RE: Oppidan 10MW DC – Daytona Rd NW Conceptual Grading and Drainage Plans Engineer's Stamp Date: 03/08/24 Hydrology File: K09D026D

PO Box 1293 Based upon the information provided in your submittal received 03/08/2024, the Conceptual Grading & Drainage Plan is preliminary approved for action by the Development Facilitation Team (DFT) on Site Plan for Building Permit.

Re: Albuqurqque Data Center Daytona Rd. NW Conceptual Traffic Circulation Layout for DFT Approval Engineer's Stamp 03-08-24 (K09-D026D)

SITE PLAN

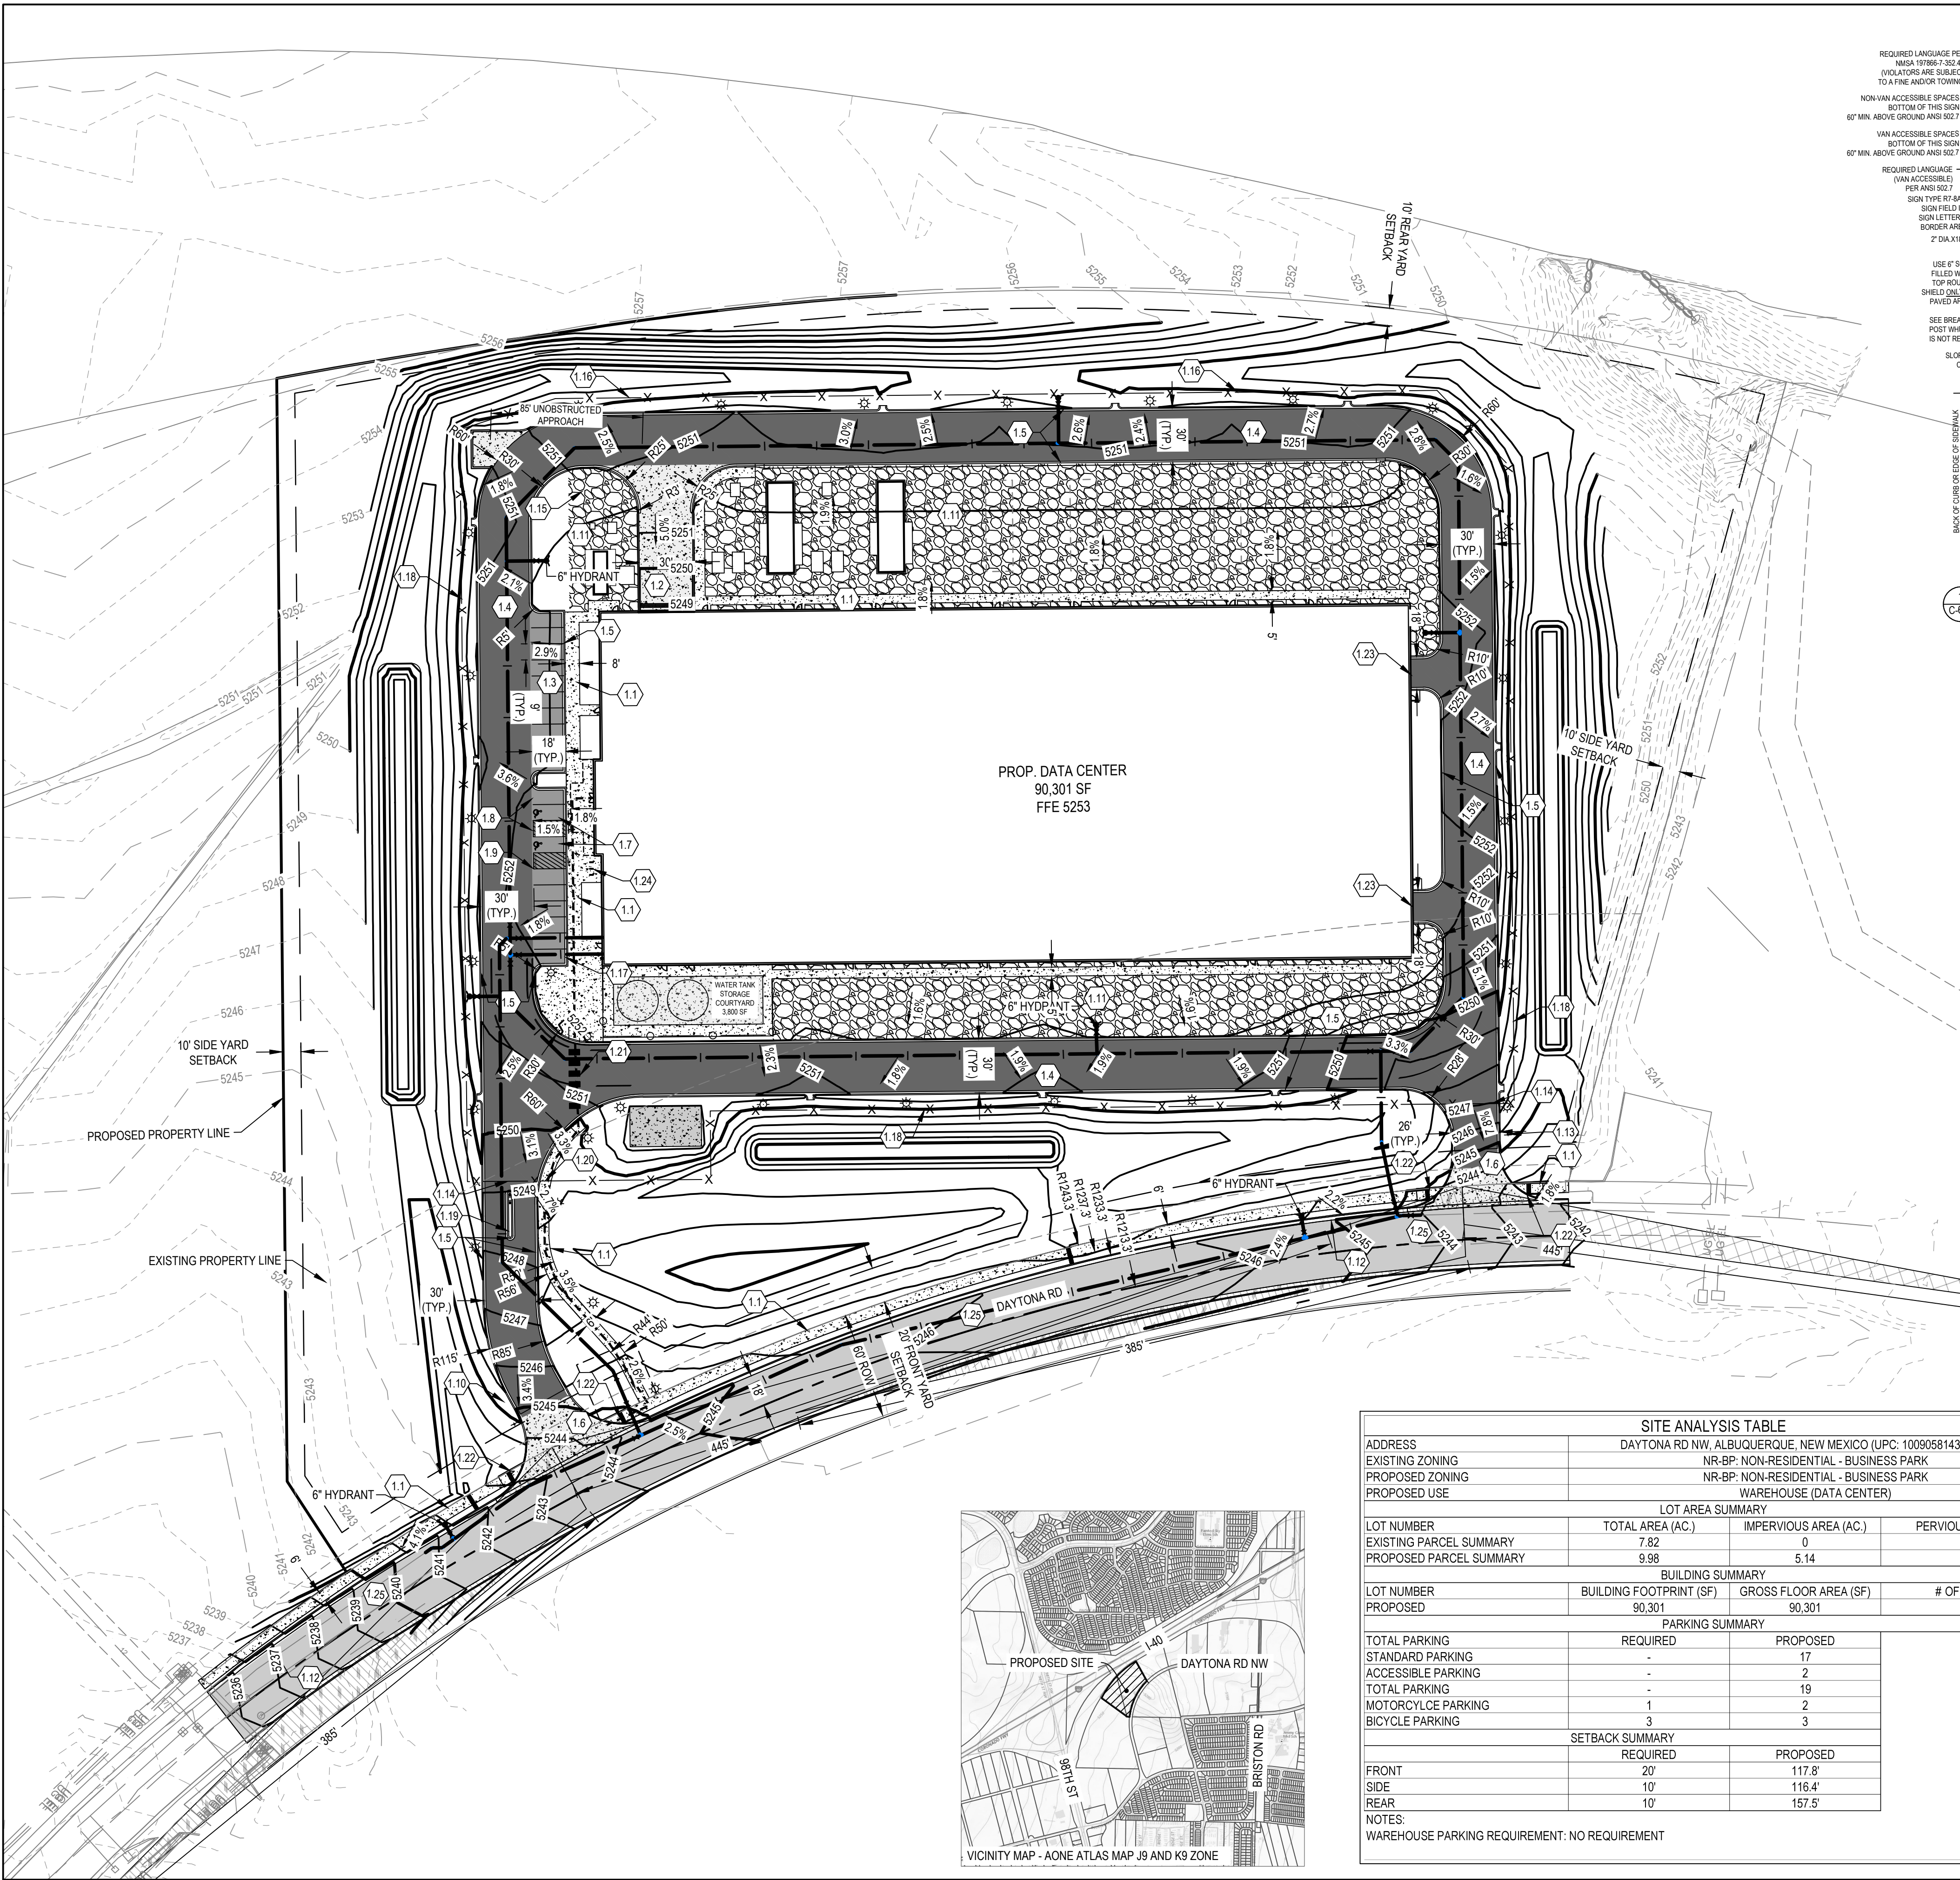
1. Remove from the TCL sheet all drainage related details.

- 2. Show on the site plan both site accesses radii.
- 3. Provide the most recent ADA parking sign. The ADA accessible parking sign must have the required language per 66-7-352.4C NMSA 1978 "Violators Are Subject to a Fine and/or Towing." Please call out detail and location of signs.
